Re: Environmental Noise Addendum Letter
Orleans Village (Phase 4), Ottawa
GW File No.: GW22-078 – Addendum Letter

Gradient Wind Engineering (Gradient Wind) has been retained by Caivan (Orleans Village 2) Ltd. to undertake an environmental noise feasibility assessment for the proposed residential development located at 245 and 275 Lamarche Avenue in Ottawa, Ontario. This letter is supplemental to our environmental noise feasibility report (ref. *Gradient Wind report #22-078 – Environmental Noise Feasibility Report*, dated April 8, 2022), to address comments received from the City of Ottawa.

Gradient Wind was provided peer review comments from the City of Ottawa in July 2022 pertaining to the environmental noise feasibility assessment. The comments addressed the Stationary Noise Control Method: Option 1. This was the preferred noise mitigation method as it did not deviate far from the proposed development design. A summary of the comments is presented below:

DESCRIPTION	FIGURE 5: STATIONARY NOISE: RECEPTOR LOCATIONS
-------------	---

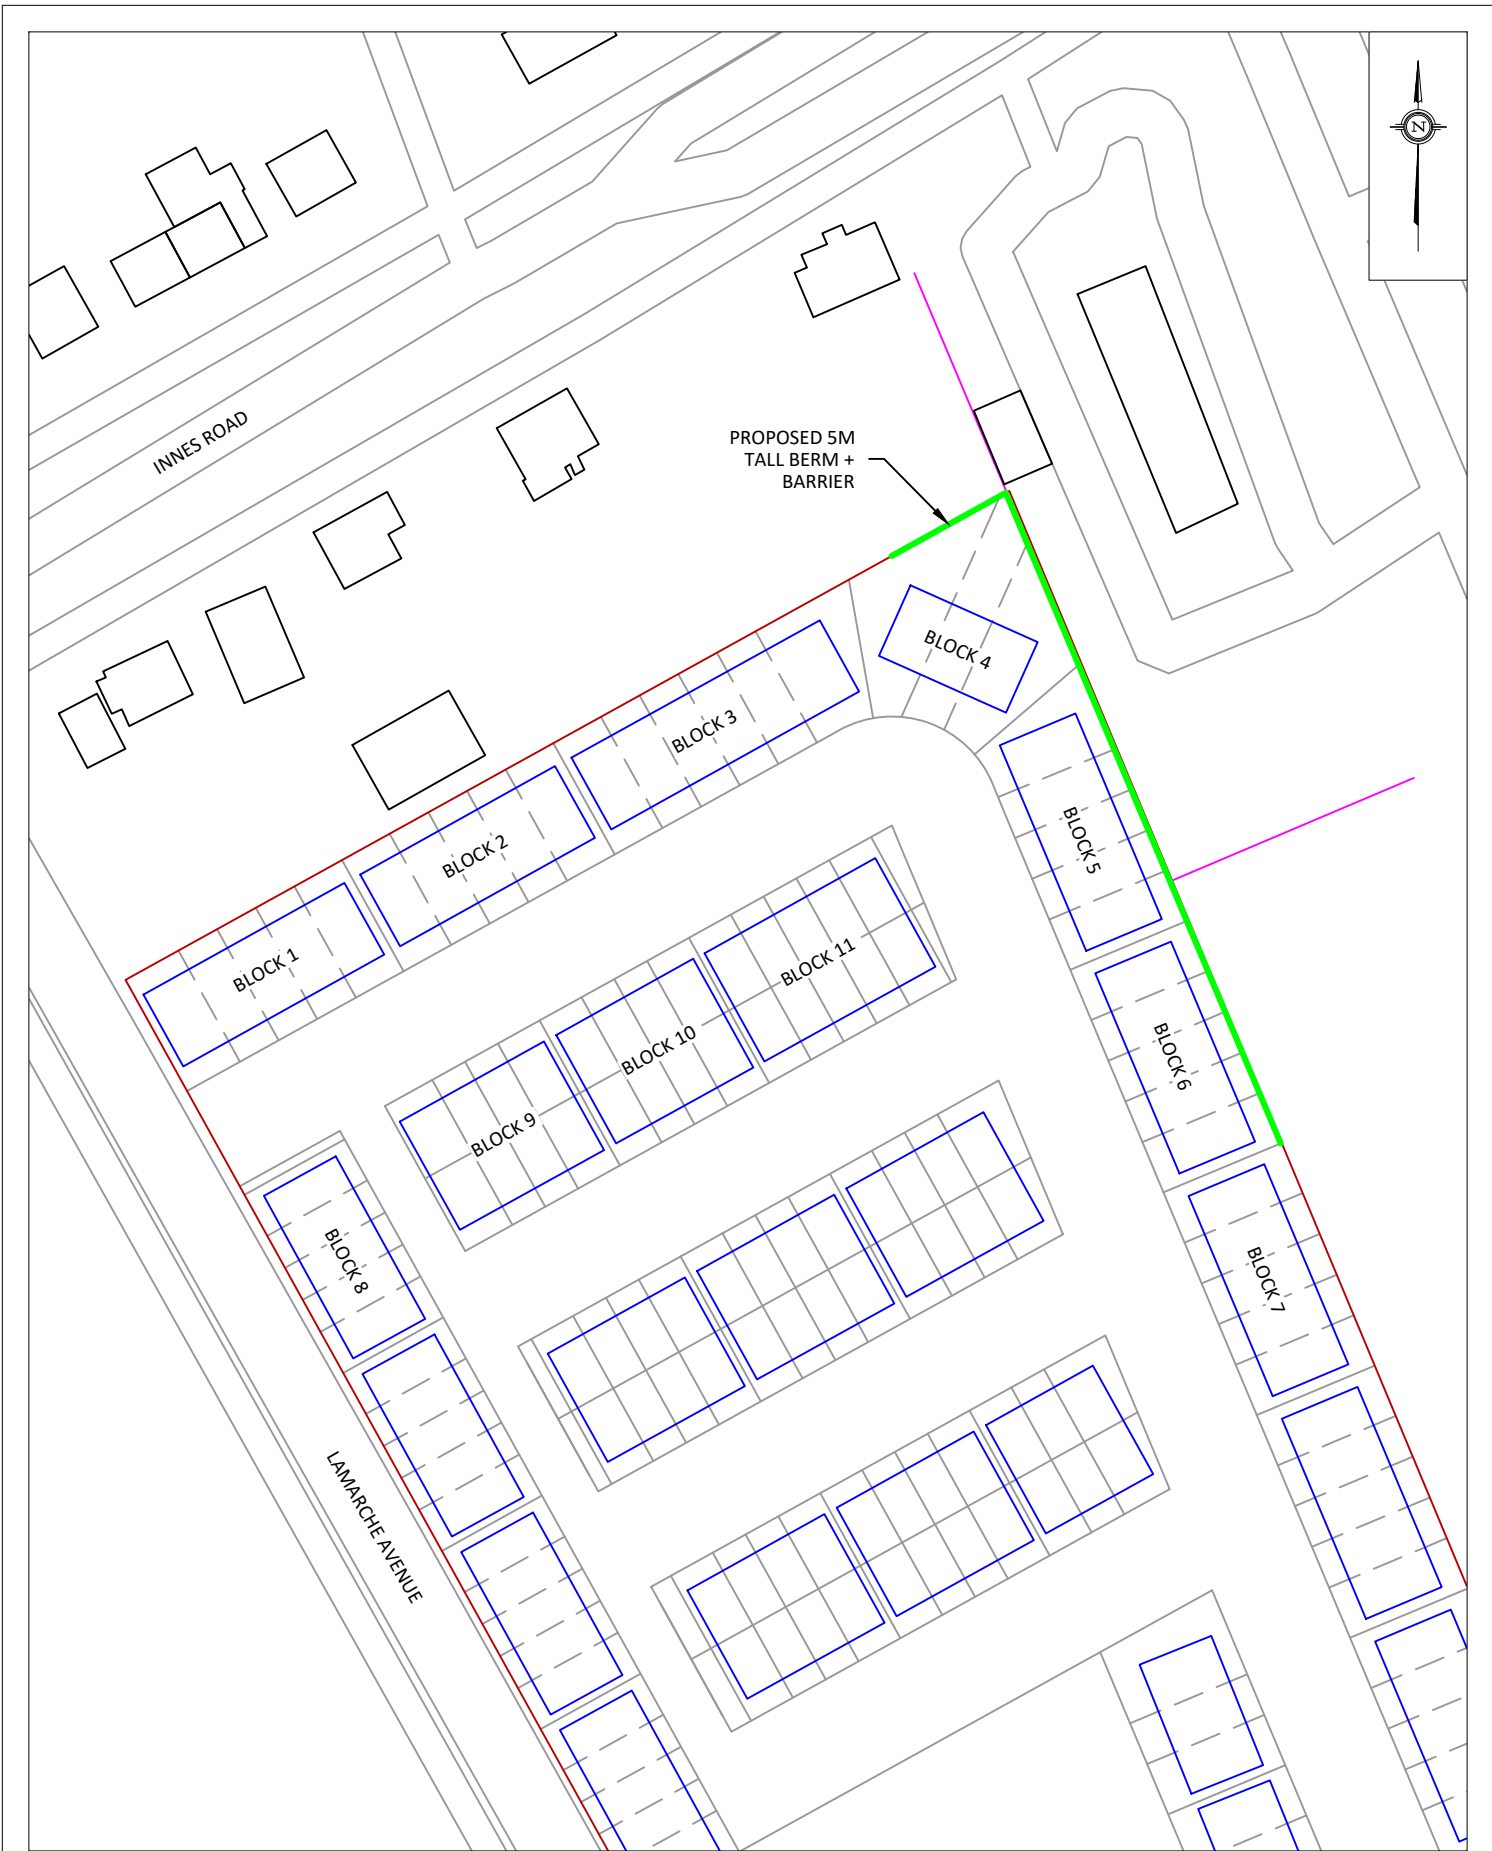
- 1. The noise study identified a 5m tall berm + noise barrier was required based upon the proposed site layout. Consideration should be made to:*
 - rearranging the subdivision lands to provide greater setbacks and result in a shorter required noise barrier, and/or;*
 - providing a different product type that would not include OLAs along the affected blocks. Note that it is the City's preference for mitigation measures that reduce the required height of the required noise barrier.*

- 2. Assess the land requirements on site to accommodate the grading of a 2.5m high berm (refer to berm setbacks within the City's Noise Control Guidelines), since the maximum barrier height that is acceptable is 2.5m. Ensure providing required barrier/berm height is feasible within the proposed block size. Alternatively, discuss the need for a retaining wall.*

As per the City's comments, Gradient Wind investigated the noise mitigating effects of implementing a 2.5 m tall noise wall/berm situated at the northeast corner of the property onto the development, primarily the rear yards. Noise receptors and the proposed barrier location are outlined in Figures 2 and 3, respectively. The proposed barrier length was also reduced such that it terminates at the boundary between Blocks 17 and 16.

The result of the current assessment indicates that noise levels can be reduced for a majority of the rear yards with the implementation of a 2.5m tall noise barrier/berm that terminates between Blocks 17 and 16. The rear yard of Block 18 is expected to experience a slight exceedance over the OPOR criterion with the 2.5 m barrier/berm. It should also be noted that the human ear is not able to perceive a difference in noise levels less than or equal to 3 dBA.
